Application No: Y/80/20/A
Site Address: Land at Street Buildings North End Road Yapton BN18 0DT
Description of works: Construction of 1 No. mounted stack sign advertisement board to West of North End Road.

Thank you for your internet representation made on 25th September 2020 which has been recorded as an objection with the comments as follows:

Title:
LOCATION PLAN

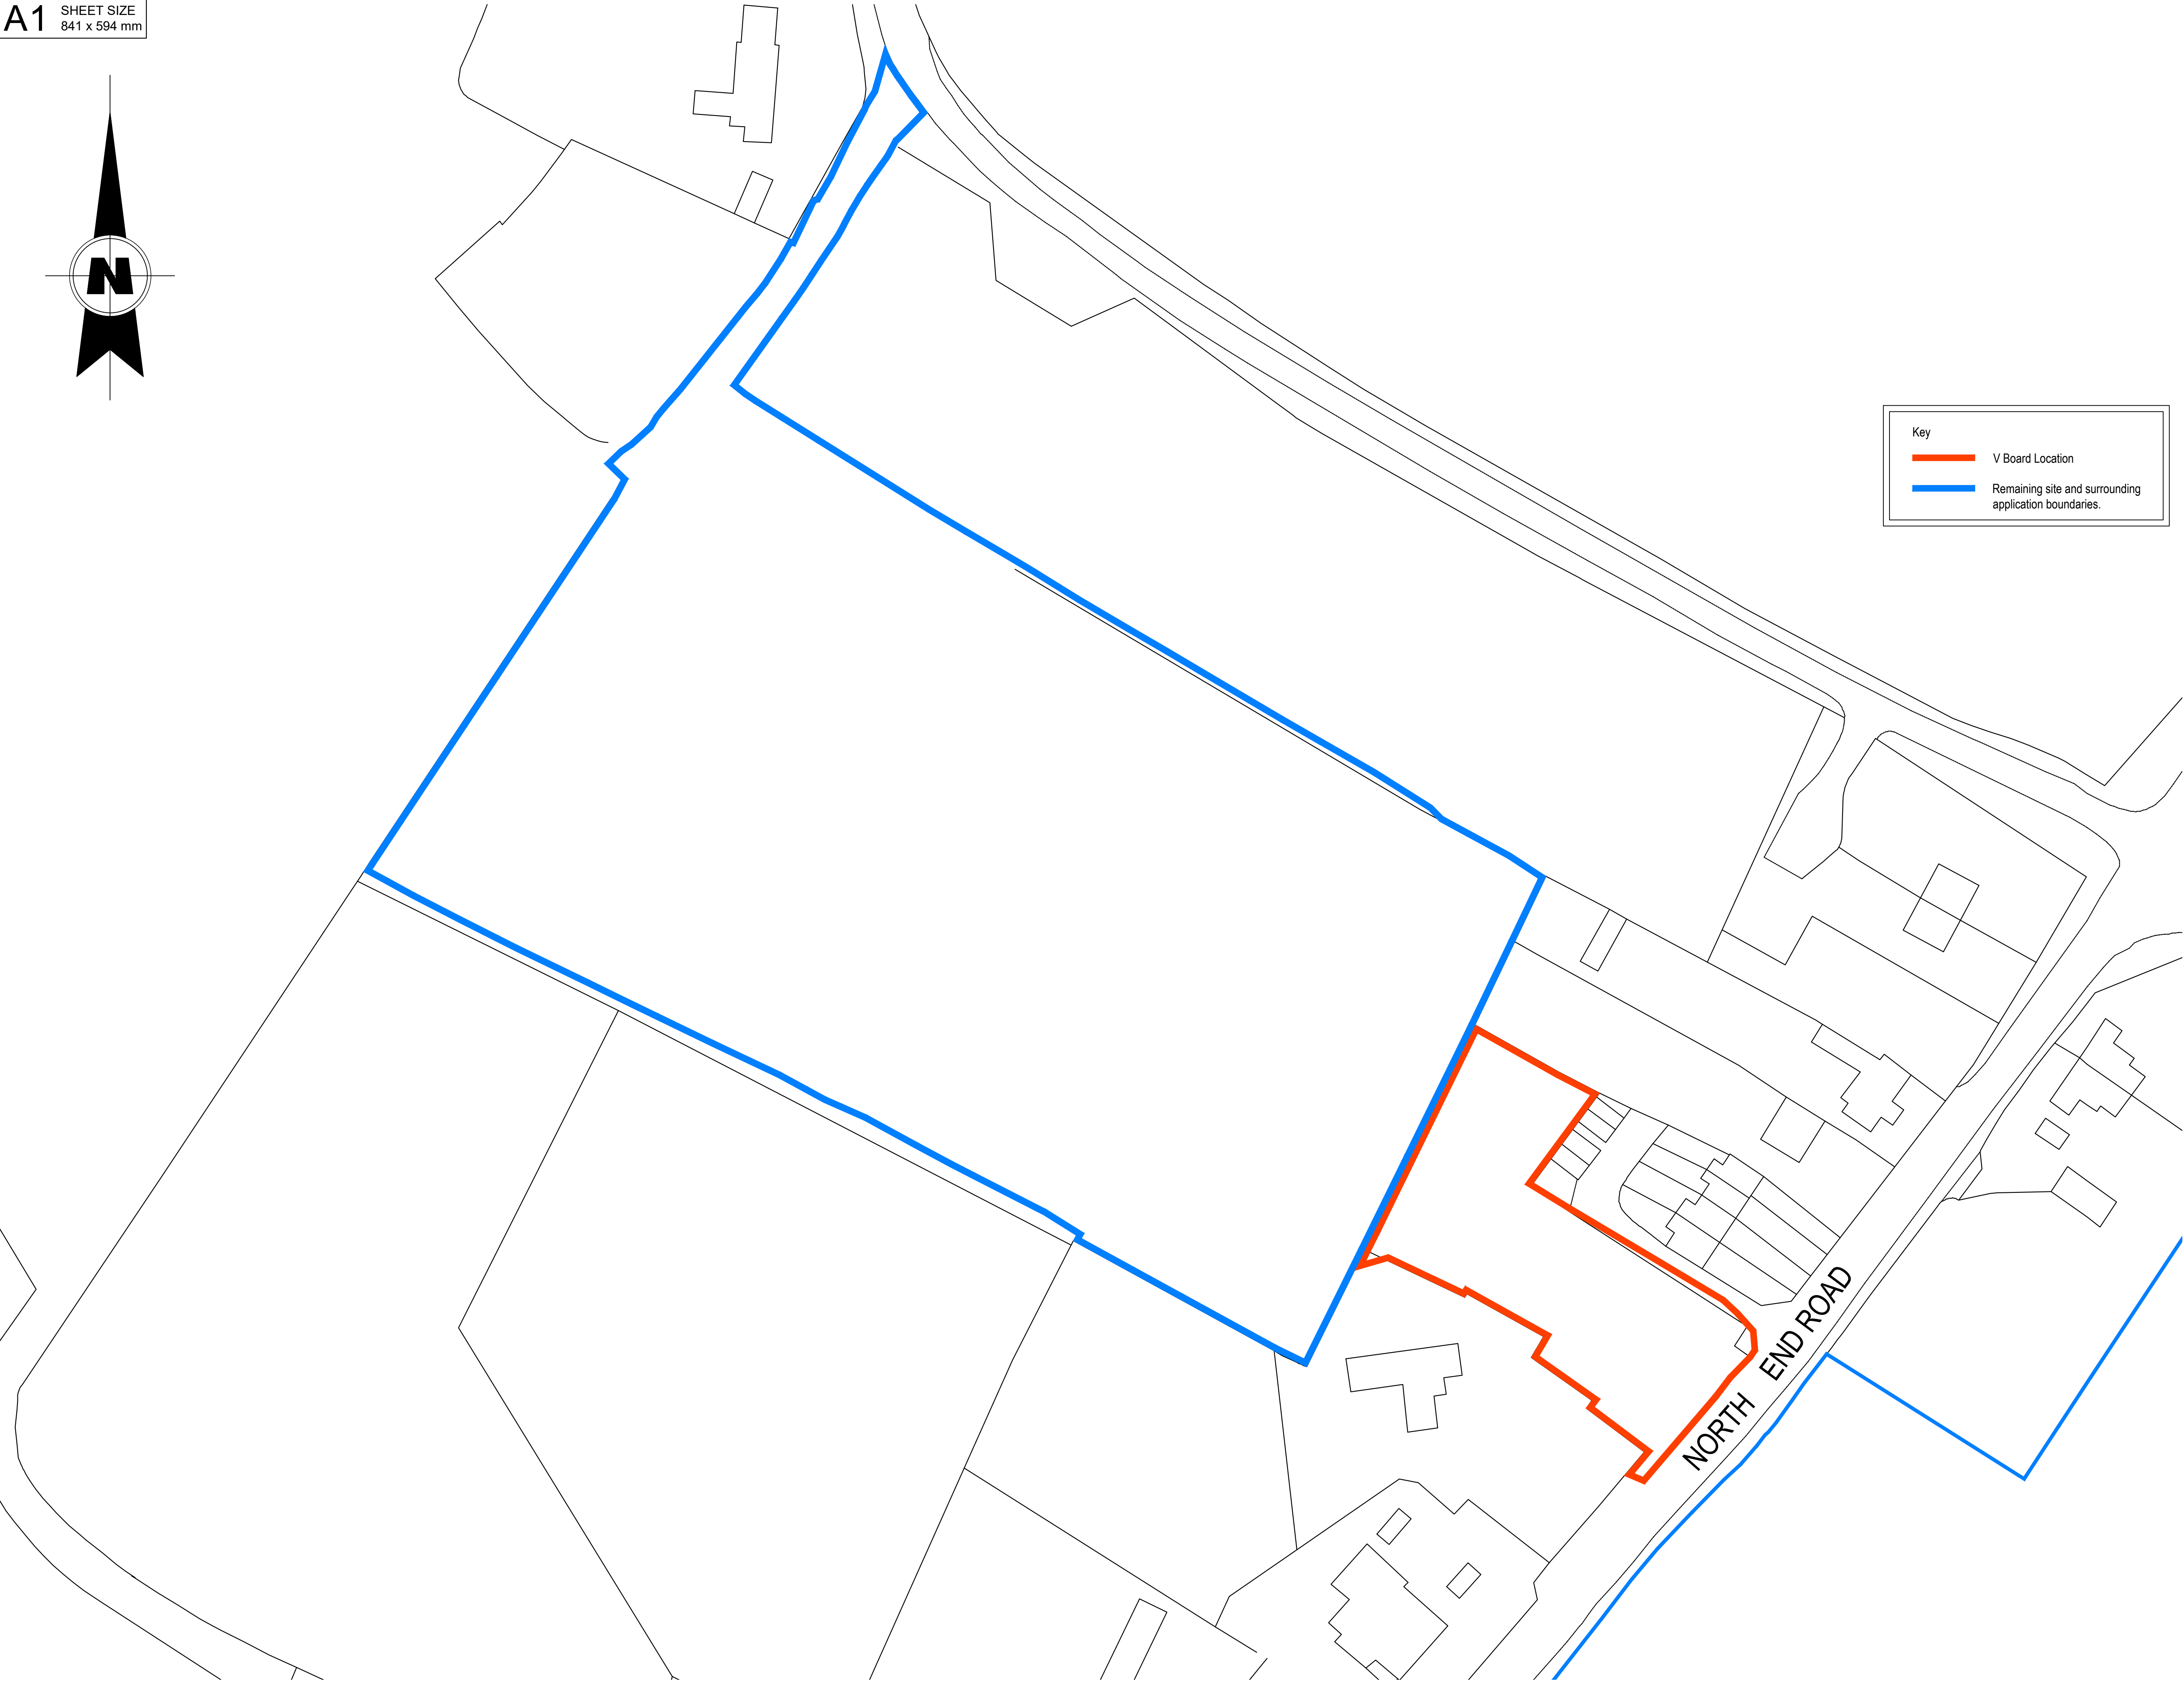
YPC object to the size of the proposed board and would suggest that it is reduced in height by at least a meter and set slightly further back into the site for highway safety. Updated from entry submitted on 24/09/20
